## Appeal Decision

**Appeal Ref: APP/R4408/W/19/3240980**

**45 Locke Avenue, Barnsley S70 1QH**

2. The description of development from the Council's decision notice and in the appeal form is the "*Erection of 4 storey detached building to house 8 no. apartments (Outline seeking approval over layout, scale, access and appearance)*". This was agreed between the main parties at planning application stage. The amended description accurately reflects the appeal proposal and therefore I have determined the appeal on this basis.
3. The planning application is submitted in outline with approval sought for layout, scale, access and appearance with landscaping details reserved for a subsequent reserved matters application.

PLANS & ELEVATIONS

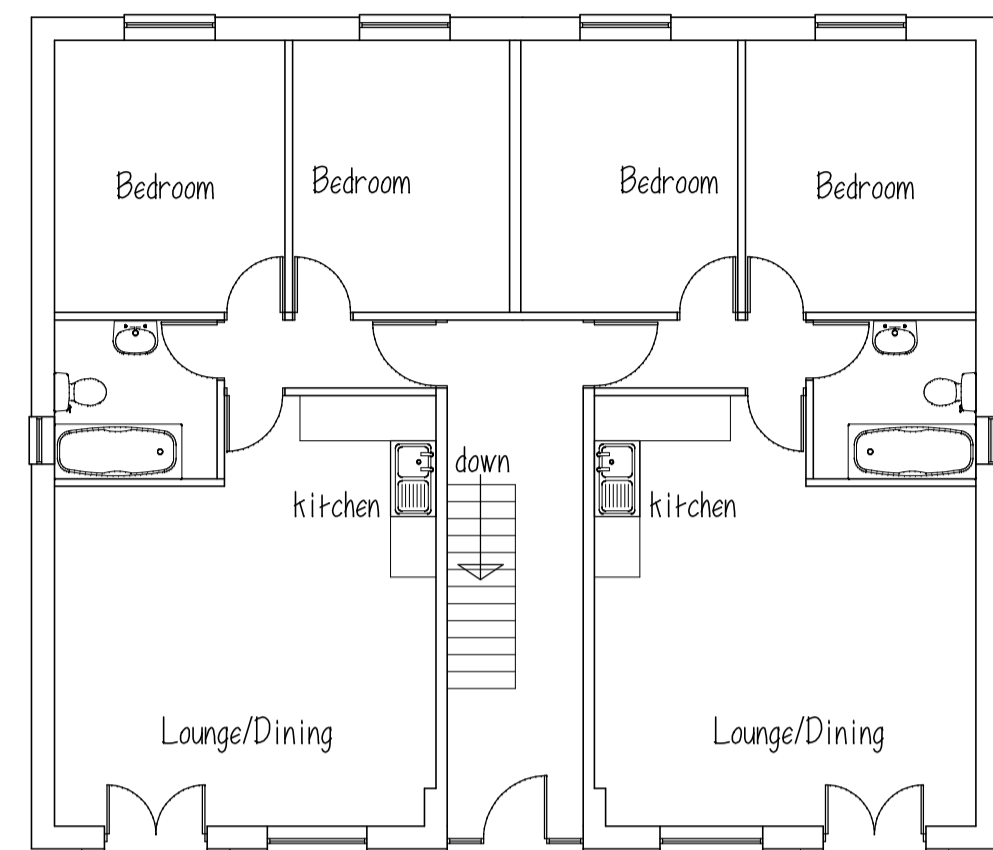
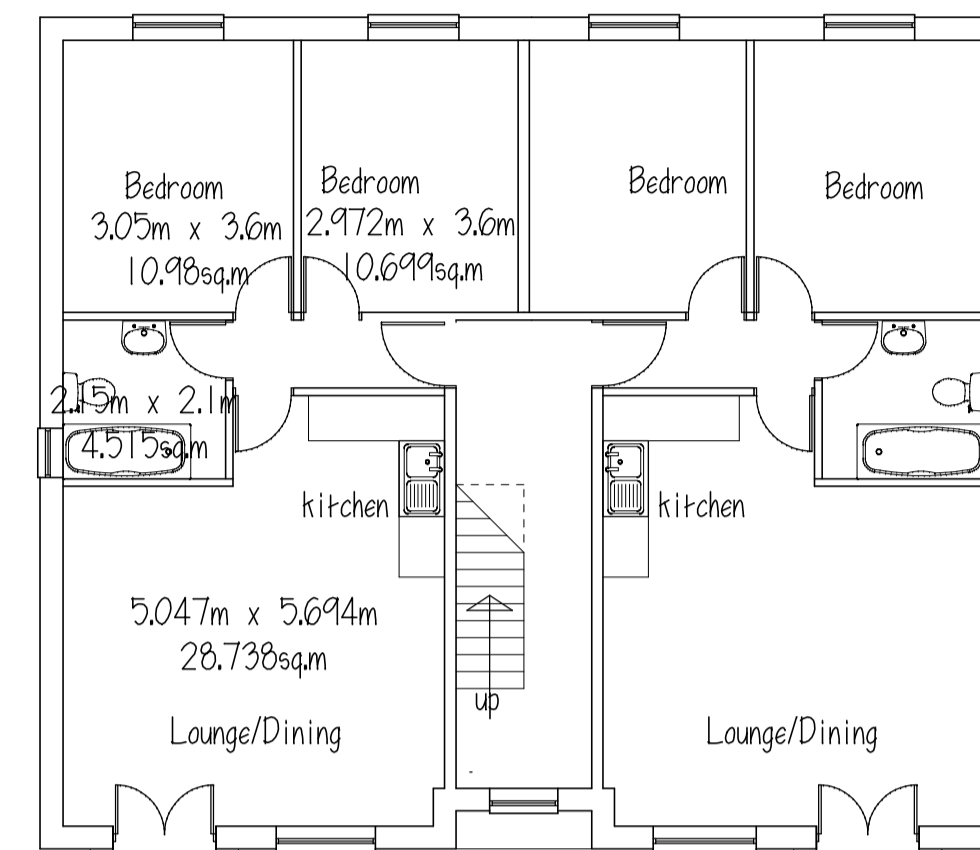
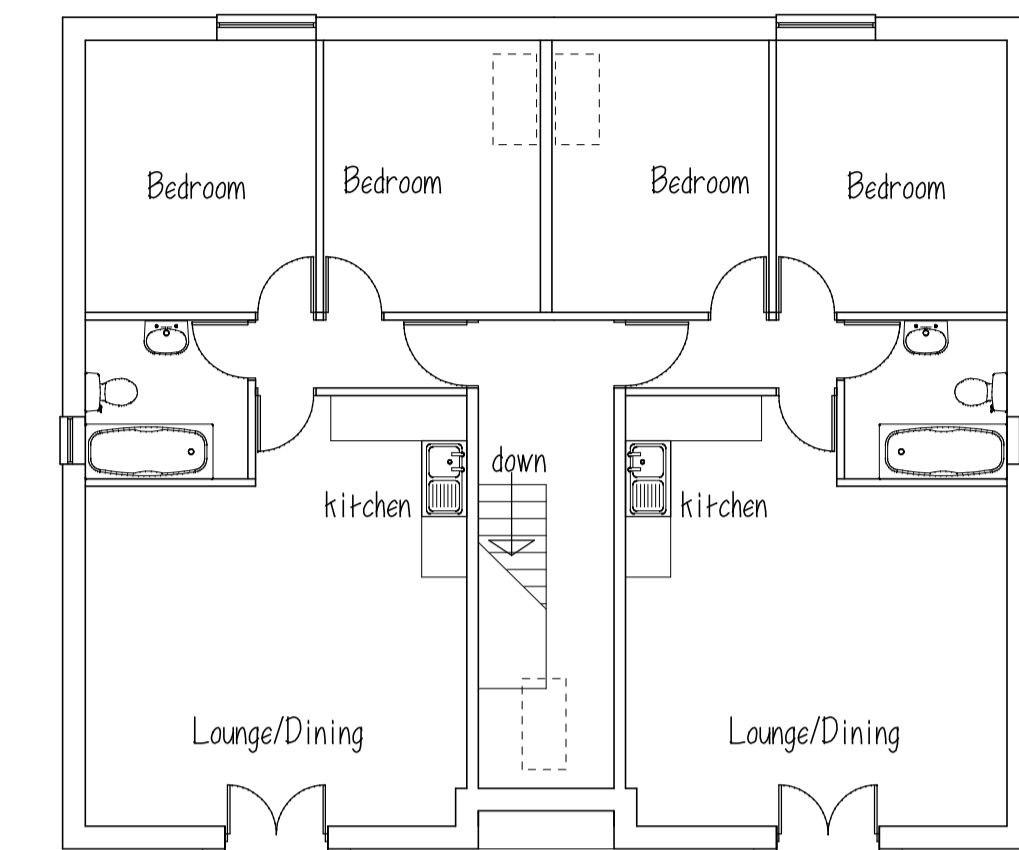
19. The Council considers that the proposed flats would fall below the minimum internal space standards contained within the South Yorkshire Residential Design Guide 2011(SYRDG) and that this would lead to unacceptable living conditions for future residents. The appellant does not dispute that there is a shortfall. I consider that as the standards set out within the SYRDG represent minimum standards any shortfall would be unacceptable and lead to unsatisfactory living conditions for future residents.

21. Owing to the proposed positioning of the appeal building and the relatively significant level drop between the site and Locke Avenue to the east, the lower ground floor flats would have a very poor outlook to the eastern and northern elevations. The master bedroom would be positioned around 4 metres away from the retaining wall on the boundary with Locke Avenue and the window of the second bedroom would be approximately 750mm from the shared boundary with No 45 Locke Road. This would significantly reduce the amount of daylight into these rooms resulting in unacceptable living conditions for the future residents of the lower ground floor flats.

FRONT ELEVATION

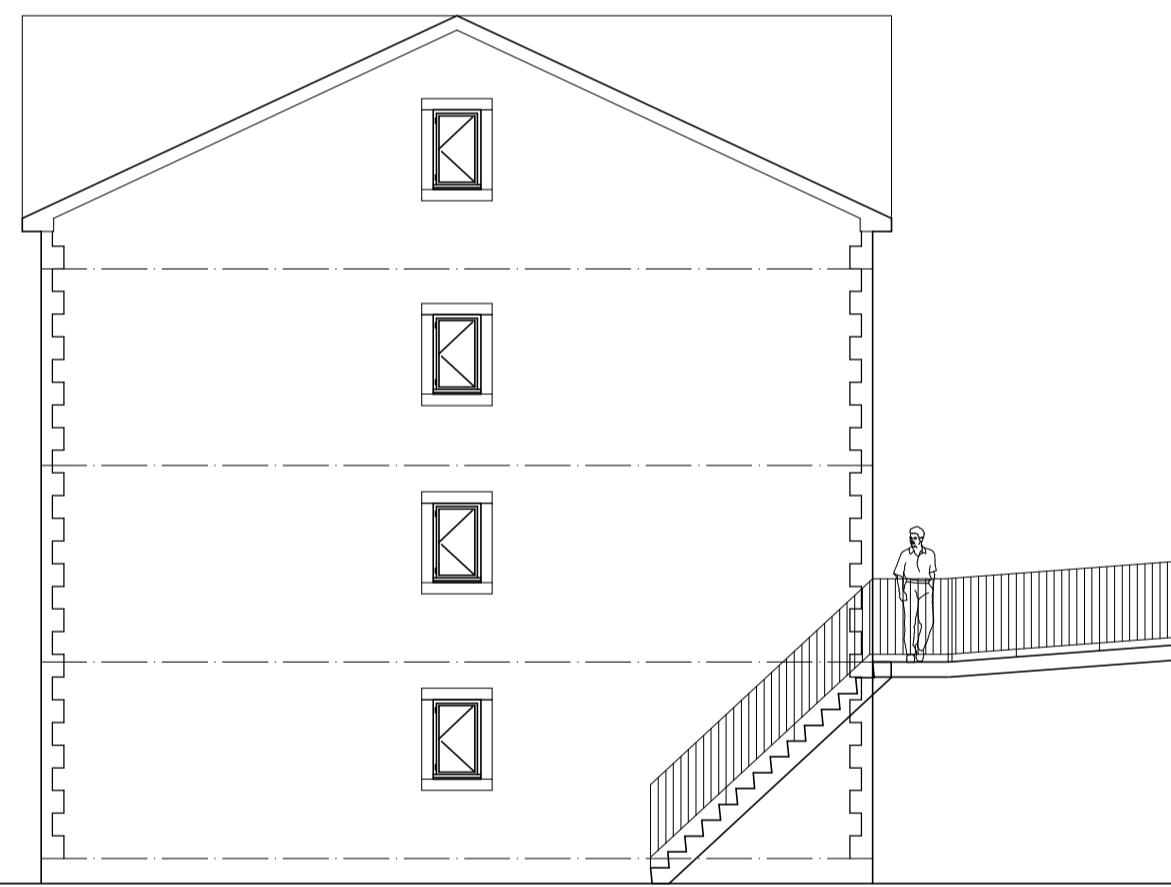
8. The appeal proposal would introduce a building that due to its scale, design and bulk would appear incongruous and out of place in the context of the adjacent single storey property and the wider street of relatively narrow two storey properties. It would sit significantly higher than No 45 Locke Road and whilst the overall height would be similar to that of the nearest two storey houses, the front facing gabled roofs, double doors and juliette balconies would jar with the simple Victorian architecture that is prevalent in the immediate vicinity.

20. The appeal property would be constructed approximately 750mm from the southern gable of No 45 Locke Avenue and set forward of its principle elevation by around 5 metres. Owing to the significant height difference and location of the building, it would have an intrusive and overbearing effect on the occupiers of No 45 Locke Avenue leading to a material loss of outlook. Furthermore, the positioning of the appeal building, due south and with the gable wall extending along the full length of the front garden of No 45, would result in a significant reduction in the amount of natural daylight into both the garden and the front windows of the property. Collectively, these issues would lead to an unacceptable impact on the living conditions of the occupiers of No 45 Locke Avenue in respect of daylight and outlook.
